OFFICIAL NOTICE OF DECISION

Project# 1010540

15DRB-70251 VACATION OF PUBLIC ALLEY RIGHT-OF-WAY

CARTESION SURVEY INC agents for ROBERT TINNIN request Vacation (Closing) for the Public Alley in Block 6, **SKYLINE HEIGHTS SUBDIVISION** located south of CENTRAL AVE SE between ALTEZ ST SE and CONCHAS ST SE. (L-20)

*Exhibit for
Proposed Vacation of a 16' Alley
Between Lots 1, 2, 9 and 10
and the West Half of Lots 3 and 8
Block 6, Skyline Heights
City of Albuquerque
Bernalillo County, New Mexico
July 2015*

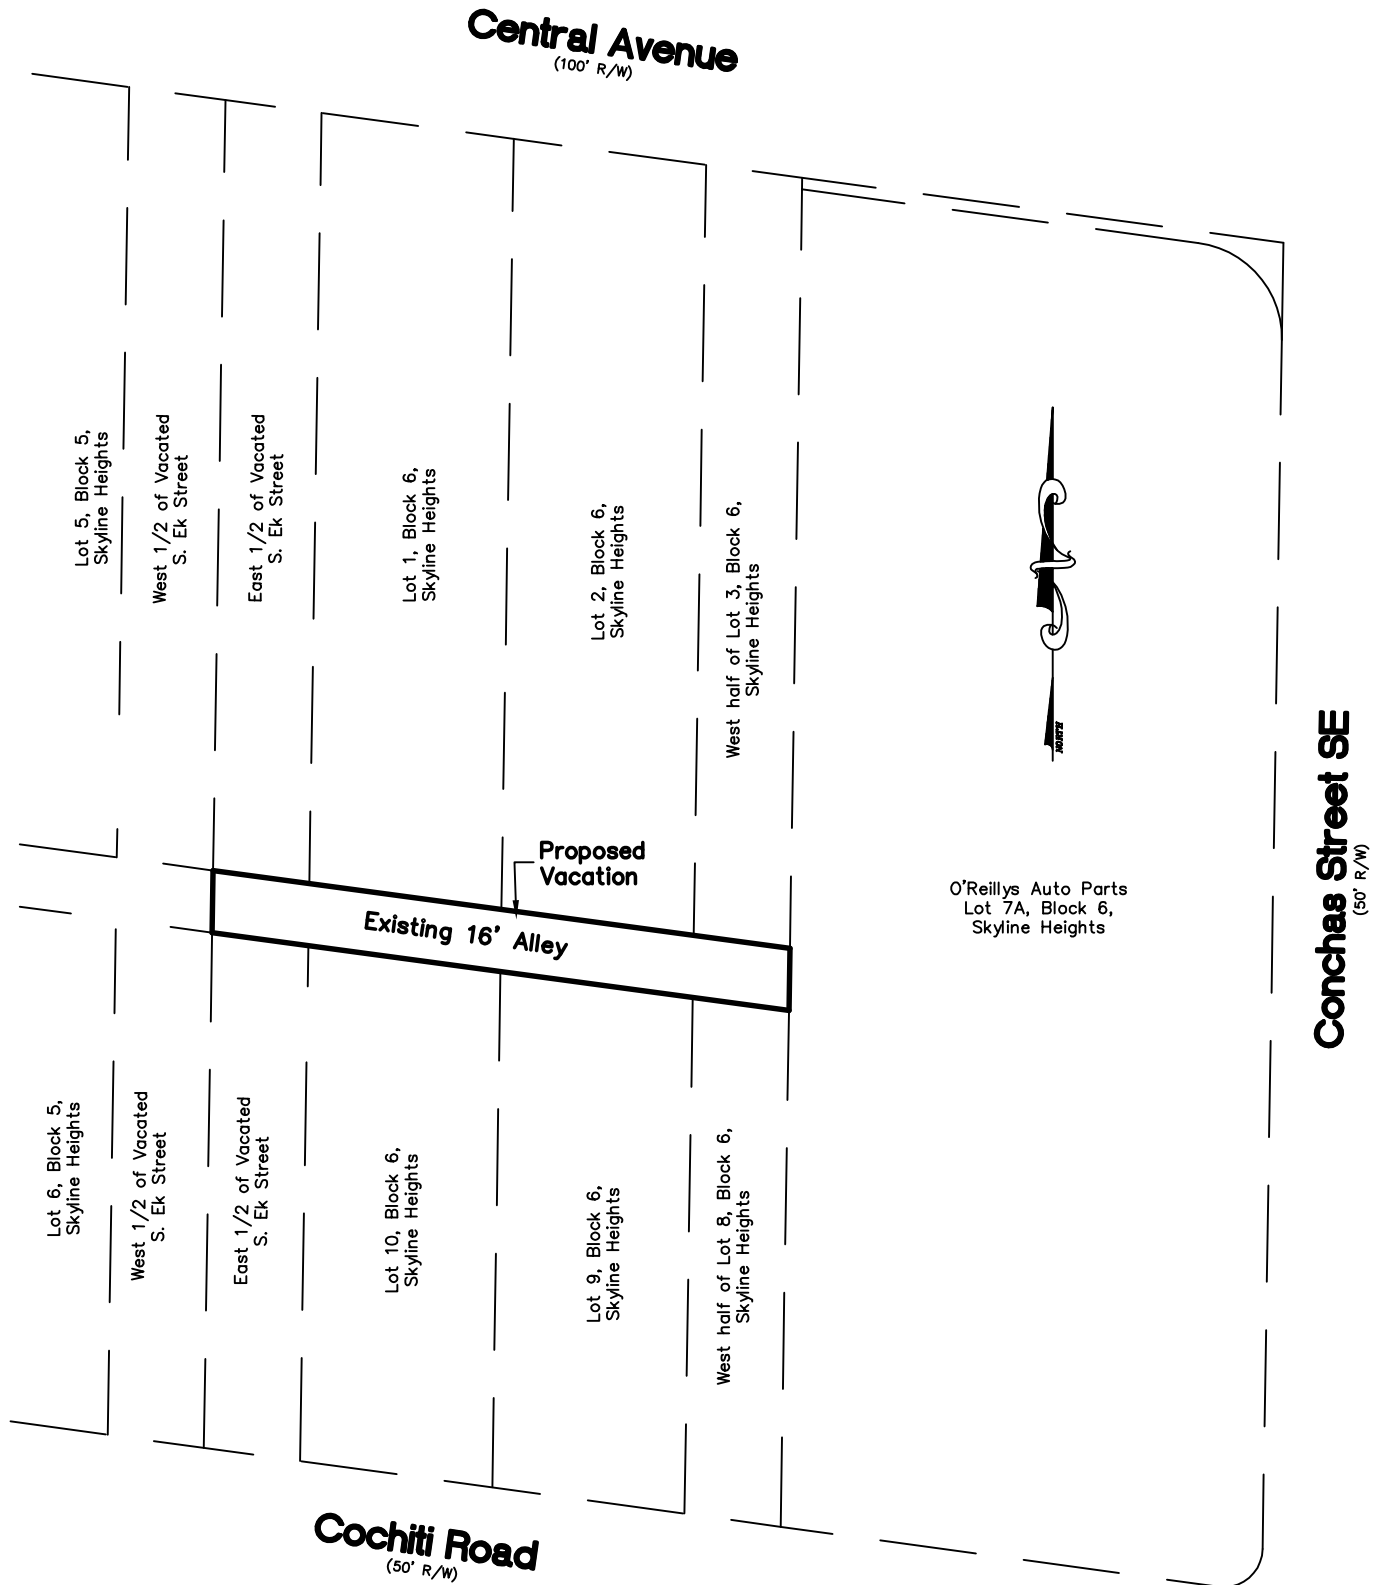
(B)(1) Based on the required replat, the public welfare is in no way served by retaining the public right of way. The City of Albuquerque does not need to utilize the 16 foot platted alley as right of way based on proposed 24 foot Public Access Easement and associated utility easements.

(B)(3) There is no convincing evidence that any substantial property right is being abridged against the will of the owner of the right; the 16 foot right of way will be replaced with a 24 foot Public Access Easement and associated utility easement such that existing property rights for access and utilities will be preserved. Property owners of record abutting the proposed vacation were notified by first class mail at least six days prior to the Development Review Board hearing, notice was published in a newspaper of general circulation 15 days before the date of the hearing, and signs were posted on the site 15 days prior to the hearing; objections presented at the hearing did not demonstrate the abridgement of a substantial property right.

3. A 24 foot Public Access Easement as well as adequate easements for public utilities and infrastructure shall be retained/ provided; franchised utility companies shall acknowledge the vacation and adequate easements by their signature on the replat.
